[REDACTED]
Cc: Neil Crowther
Subject: Discharge of conditions application LU/96/16/DOC

I am the officer dealing with the above discharge of conditions (DOC) application for the Bovis Site at Hampton Park. Having reviewed some of the information submitted and some of the consultation responses received, please see my comments below:

Drawn by: hb, Date: MAR. 15, Drawing No: LITL-905 B

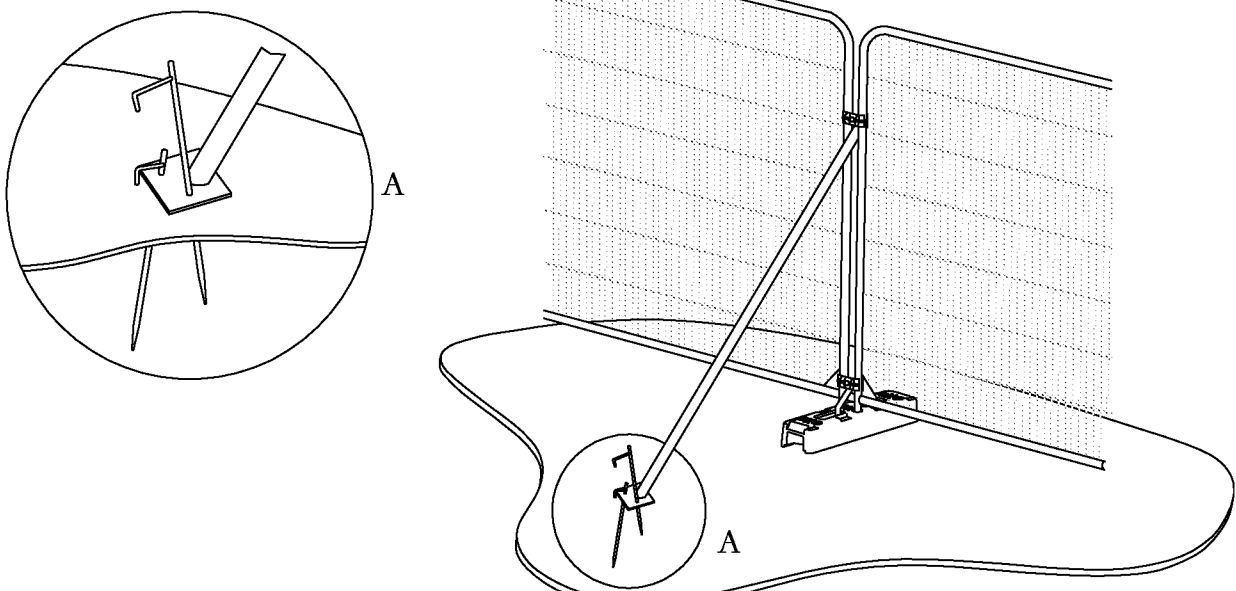
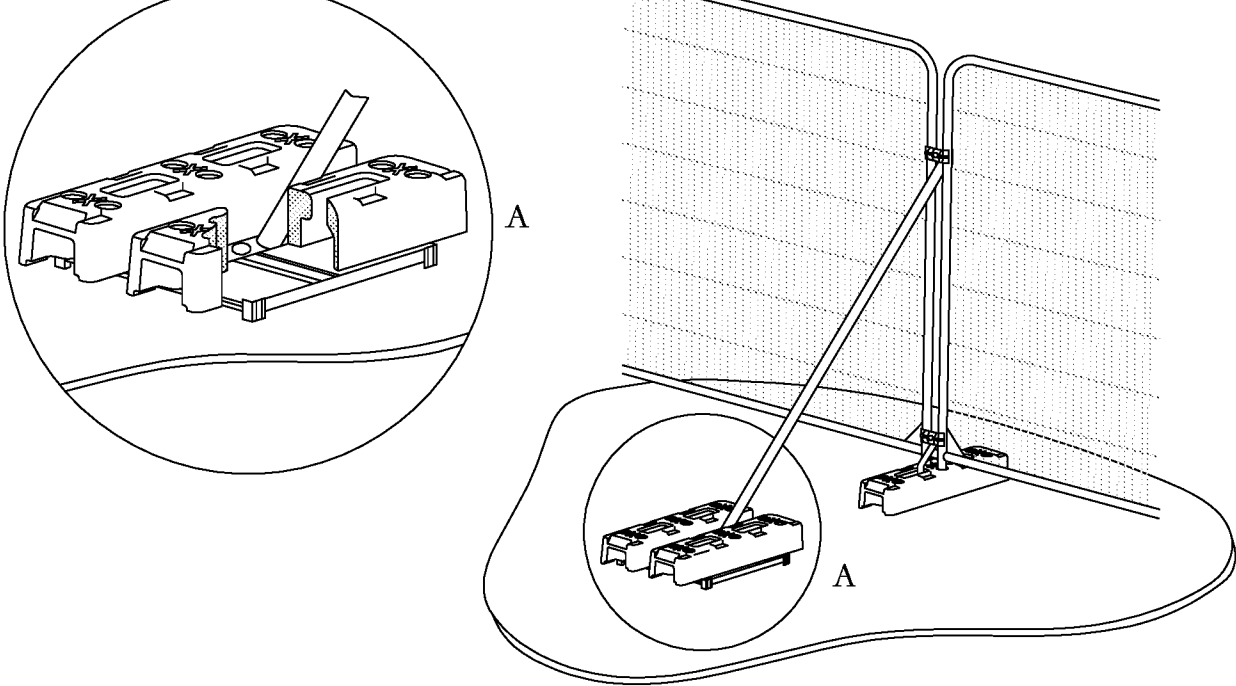
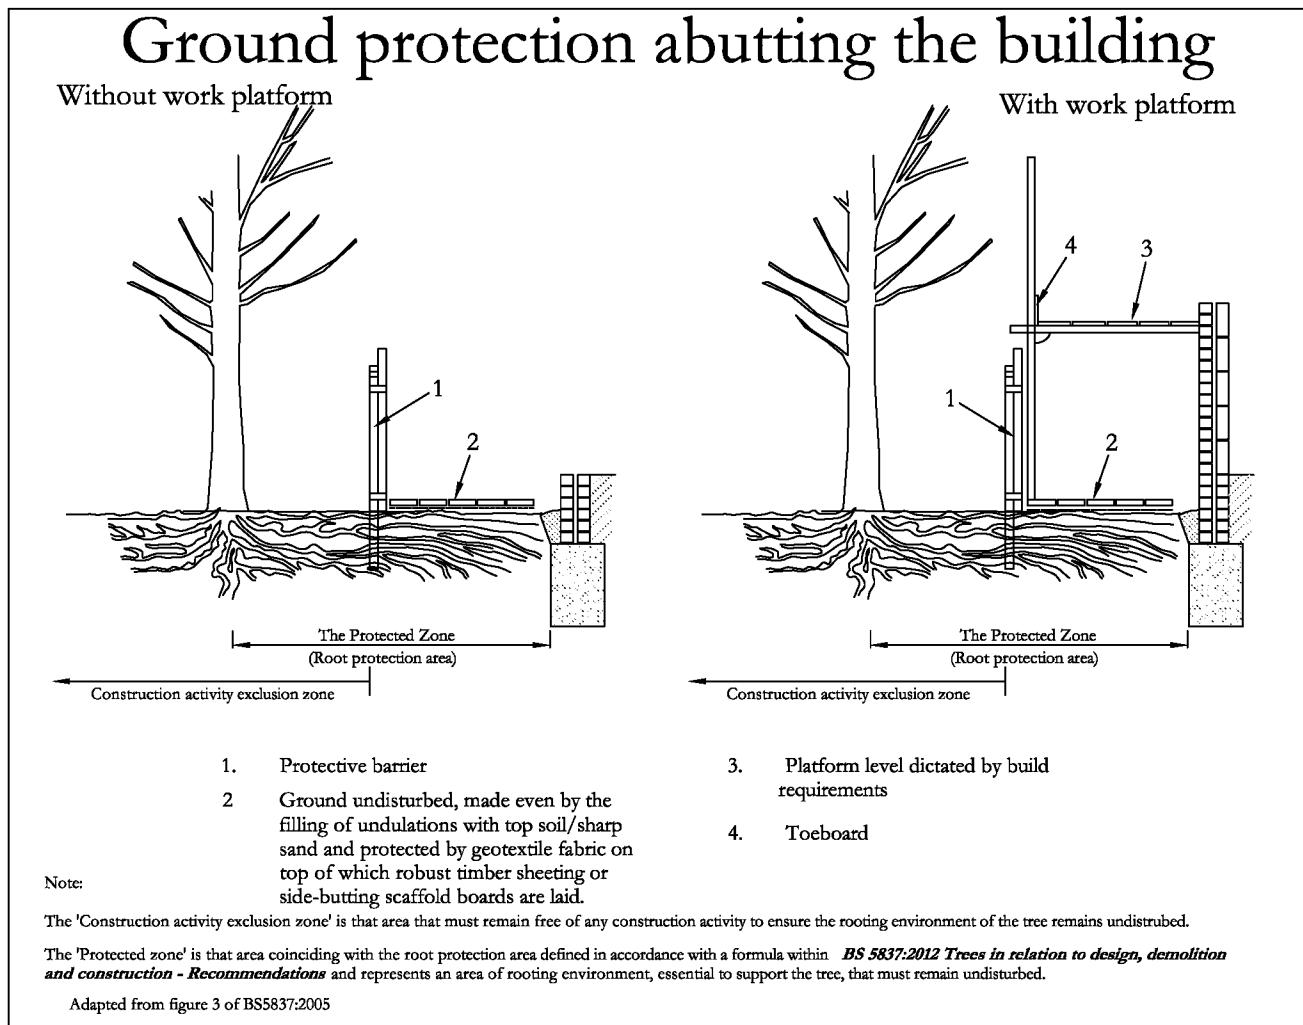
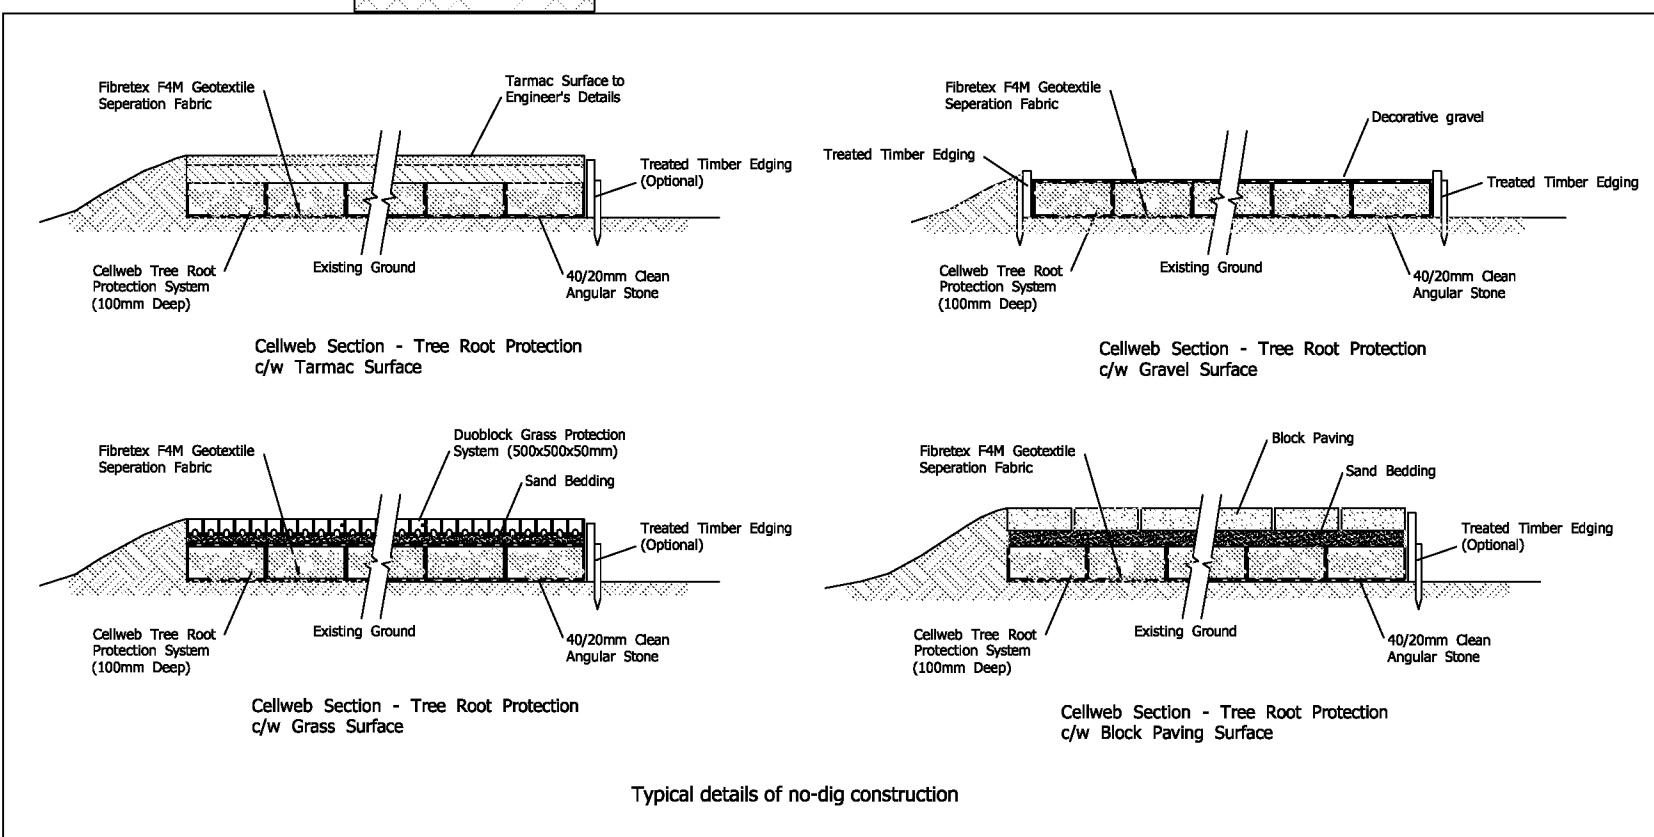
Conditions 14 (landscaping) and 15 (tree protection): the ADC Tree Officer has objected to the submitted information as a proposed dwelling (plot 25) is located within the Root Protection Area of T1. There is no method statement or mitigation measures on how this would be achieved in accordance with BS 5837:2012. Therefore, I will not be able to discharge this conditions until an acceptable method statement and mitigation measures are provided. Until this issue is resolved please ensure that the tree protection barrier around T1 aligns with the Root Protection Area, rather than the area illustrated on the submitted Plan. There has been no objection from ADC Landscaping officer on the soft landscaping scheme. **Please could you submit a revised plan and method statement to address the points raised and confirm that a tree protection barrier will be placed around the RPA of T1 with immediate effect.**
